Rezoning Transportation Analysis
Petition Number: Insert Zoning Petition #2021-056
General Location Identifier: 04105416

Revision Log:

| Date | Description |
|------------|----------------------|
| 03-24-2022 | Seventh Review (PDM) |

REZONING PLAN

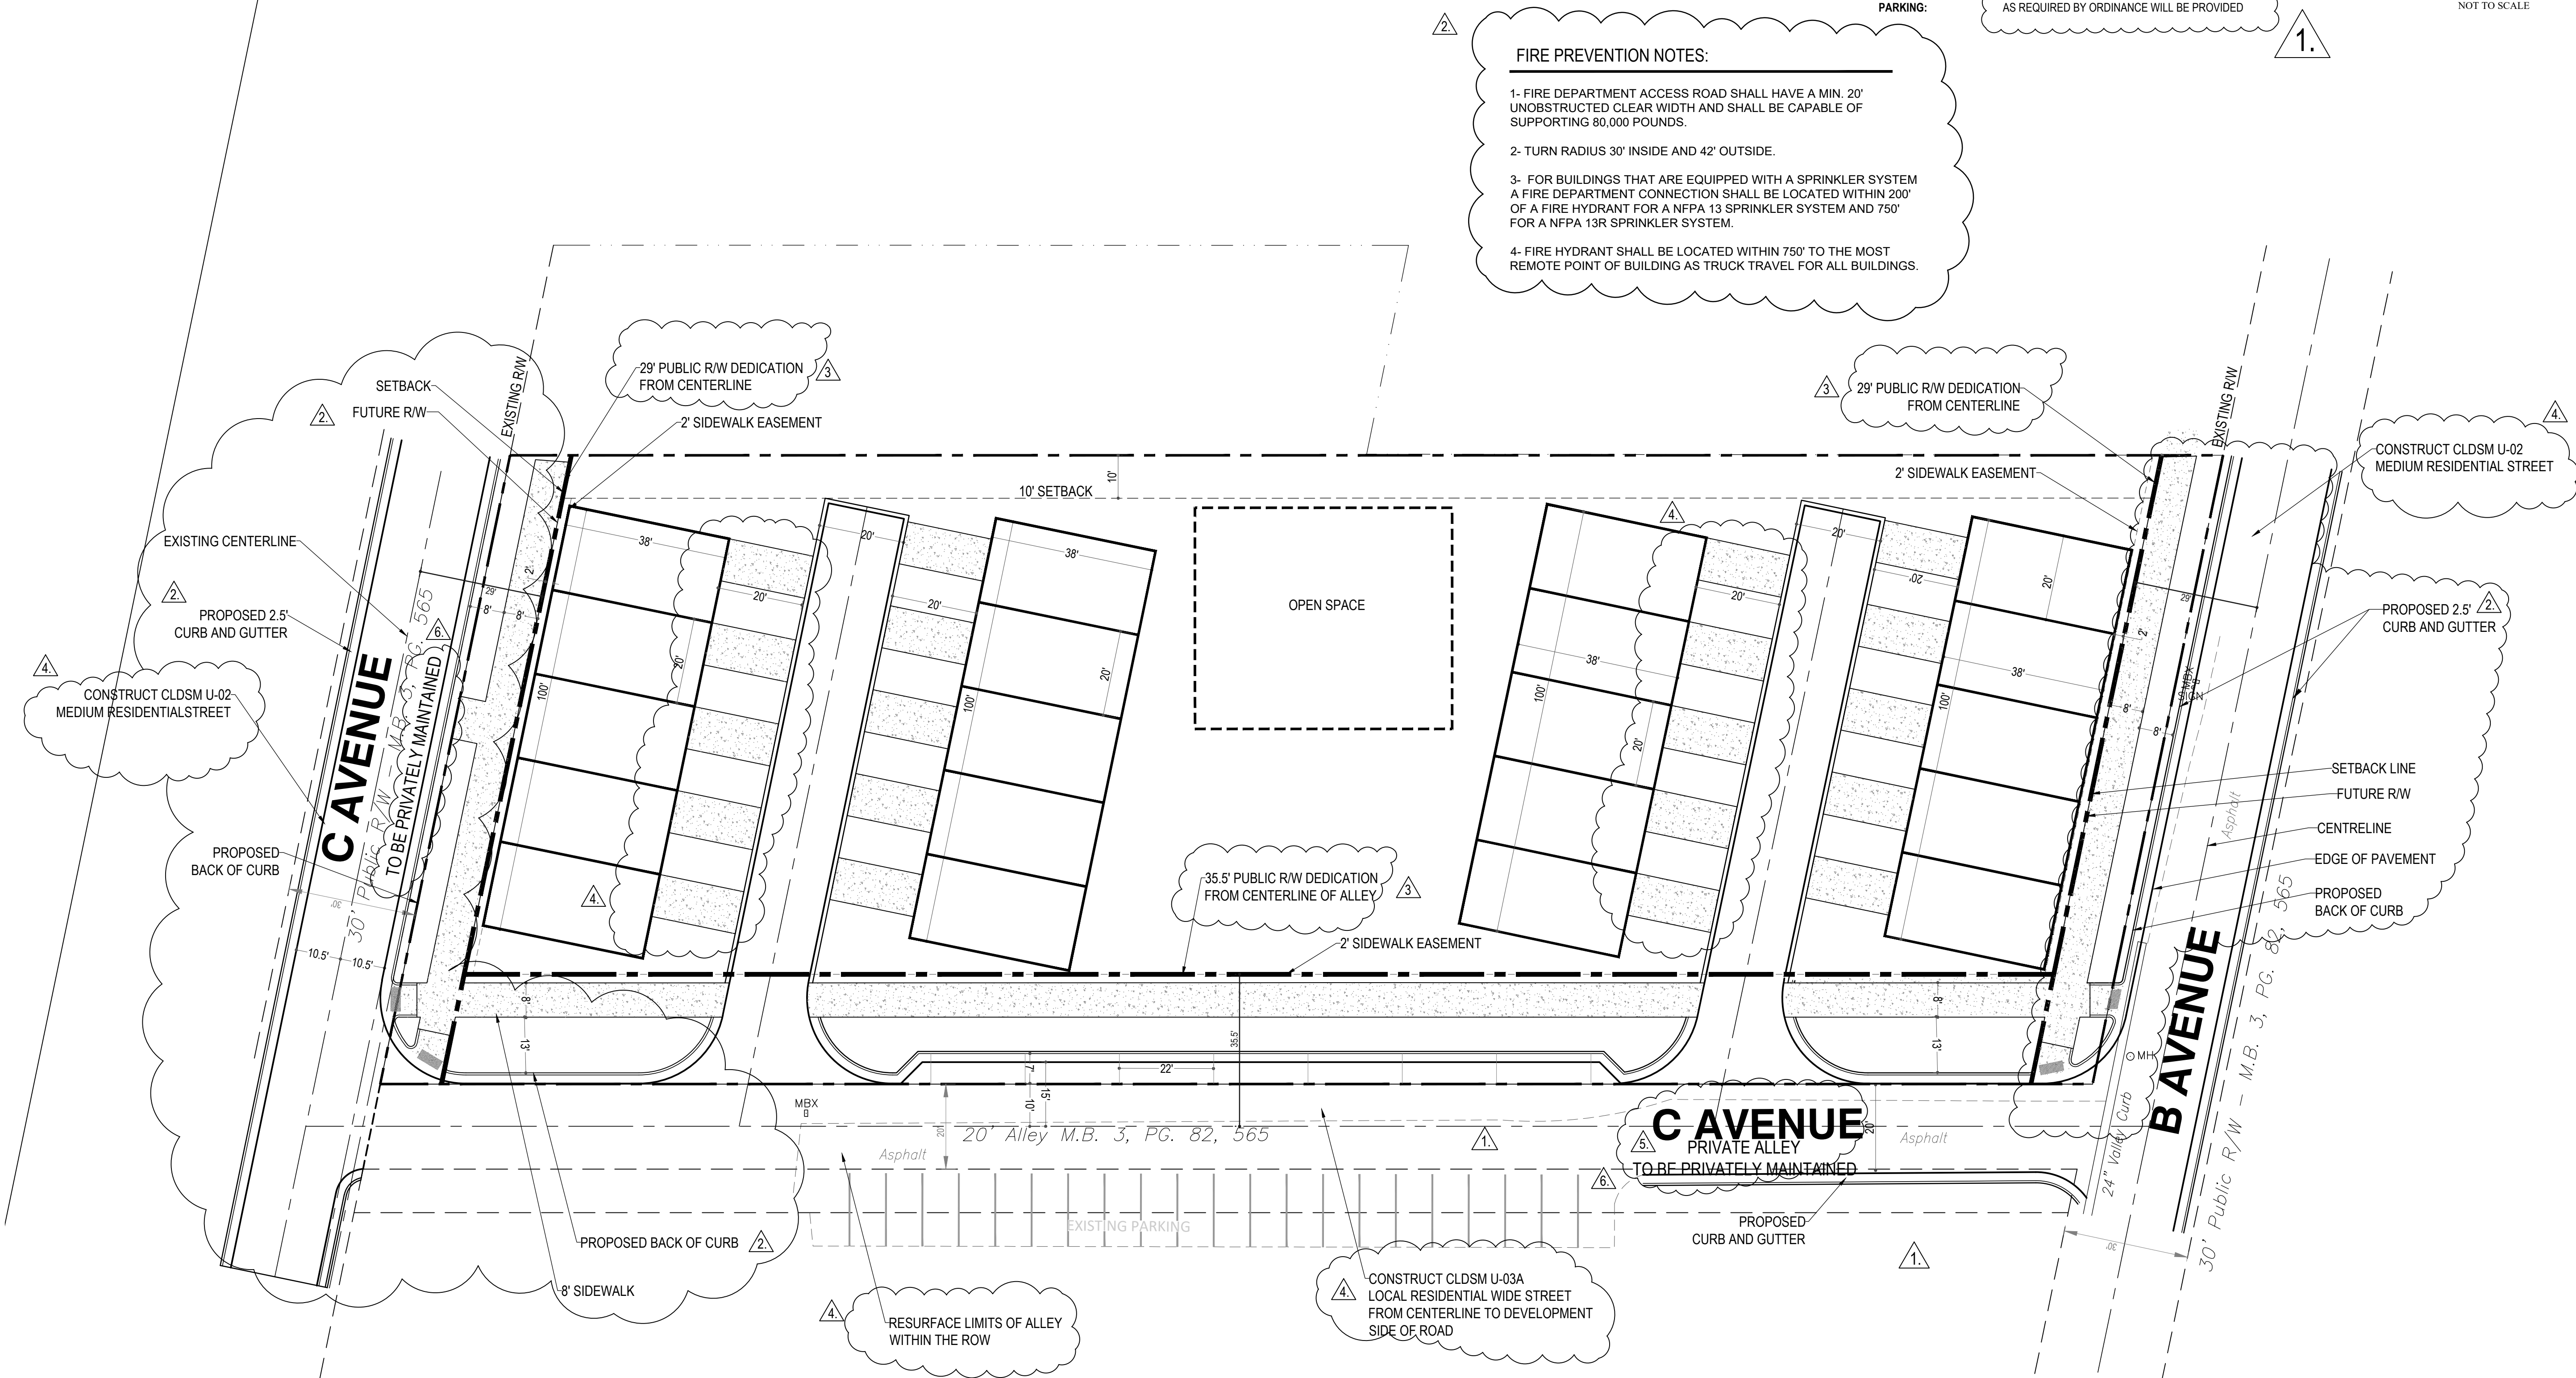
7. **Outstanding Comment:** A site plan note(s) specifying dedication and fee simple conveyance of all rights-of-way to the City before the site's first building certificate of occupancy is issued is needed. CDOT requests rights-of-way set at 2' behind back of sidewalk where feasible.

Drawing No. **RZ-2.0**

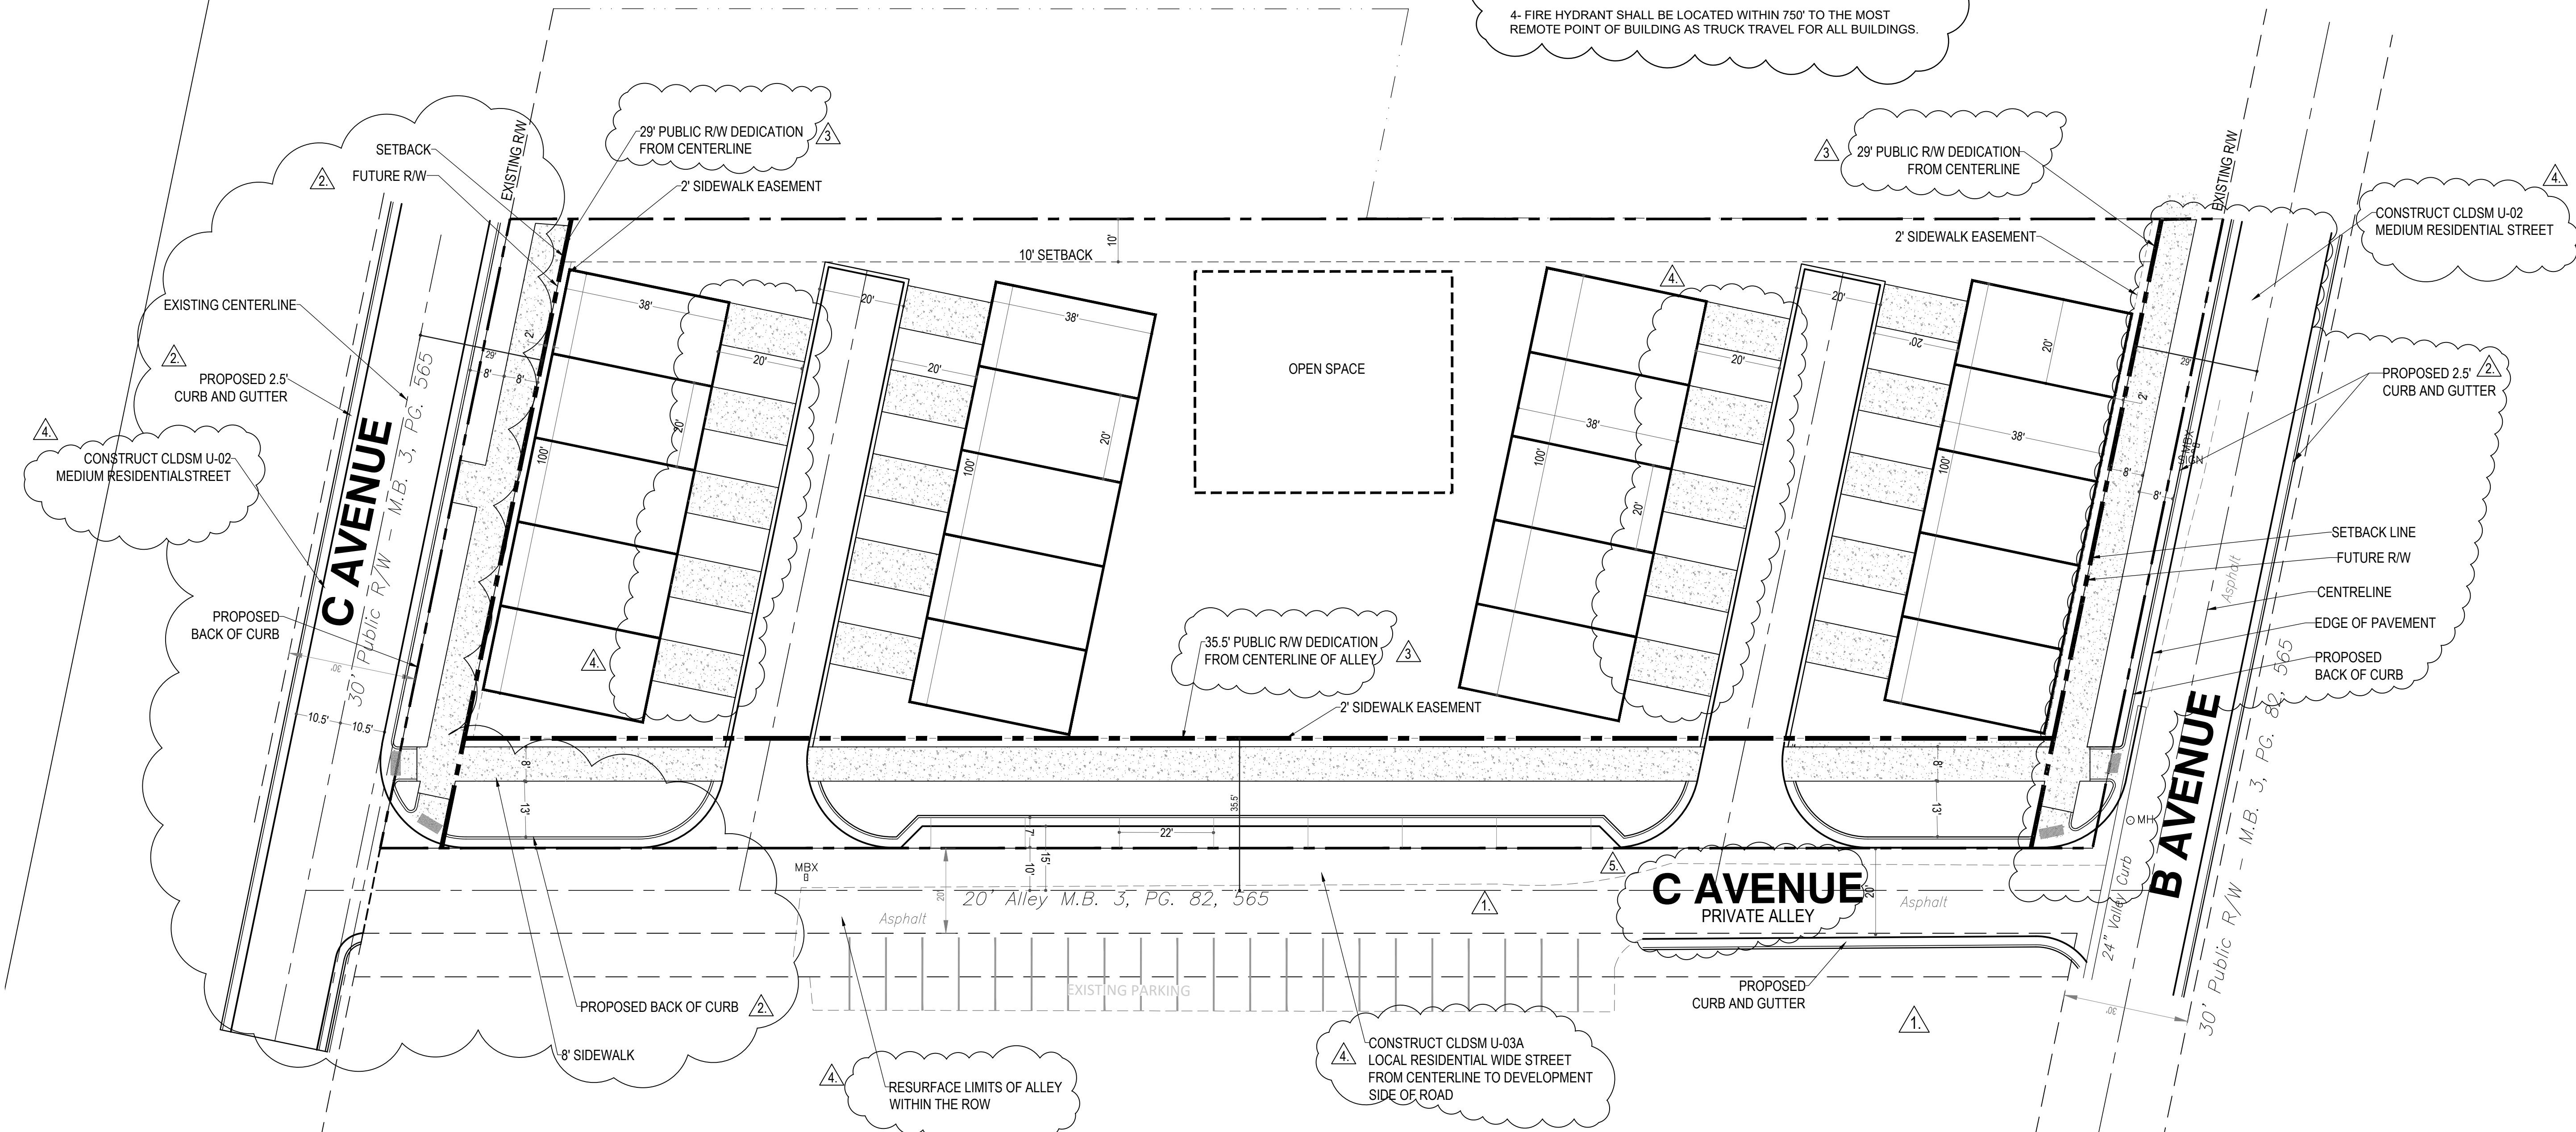
6. **Outstanding Comment:** Revise site plan and conditional note(s) to commit to construct two PROWAG ramps at the alleyway / paper right of way intersections with North Avenue (now labeled C Avenue) and B Avenue (**Comment clarification on 10/18/21** – two ramps per corner).

9. **New Comment (revised on 01/27/2021 based on updated site plan):** Revise site plan and conditional notes to specify Avenue B and Avenue C (formerly labeled as North Ave) as residential medium streets per CLDSM U-02. The site plan shall call out each road as CLDSM U-02. A conditional note shall be added to the plans stating Avenue B and Avenue C (formerly labeled as North Ave) will be constructed to the standard outlined in CLDSM U-02.

10. ~~New Comment (revised on 01/27/2021 based on updated site plan):~~ Revise site plan and conditional notes to specify Avenue C alley as residential wide streets per CLDSM U-03A. The site plan shall call out the road as CLDSM U-03A. A conditional note shall be added to the plans stating Avenue C Alley will be constructed to the standard outlined in CLDSM U-03A from the centerline of the road to the development side of the road as outlined in previous memo comment 1.C.
11. ~~New Comment (revised on 01/27/2021 based on updated site plan):~~ Revise site plan and conditional notes to commit to resurfacing the entire limits of C Avenue Alley within the right of way in accordance with the pavement schedule outlined in CLDSM U-03A. This includes the area from the centerline of the road to the right of way line to the west side of the roadway.

12. ~~Outstanding Comment (revised on 01/27/2021 based on updated site plan):~~ Revise site plan to relocate the multi-use path along C Avenue alley to reduce the planting strip to 8ft along the roadway (locate multi-use path 10.5 feet from the edge of travel lane). Based on the current site plan for the townhomes, the setback from the right of way required by zoning is not met. Confirm setback requirements with zoning. Right of way dedication can be reduced to 2ft behind the relocated multi-use path (30.5 ft from centerline).
13. **New Comment 03/02/2022:** Revise site plan to call out the C Avenue alley as privately maintained. **(Comment clarification on 03/21/2022 – both portions of C Avenue to be privately maintained).**
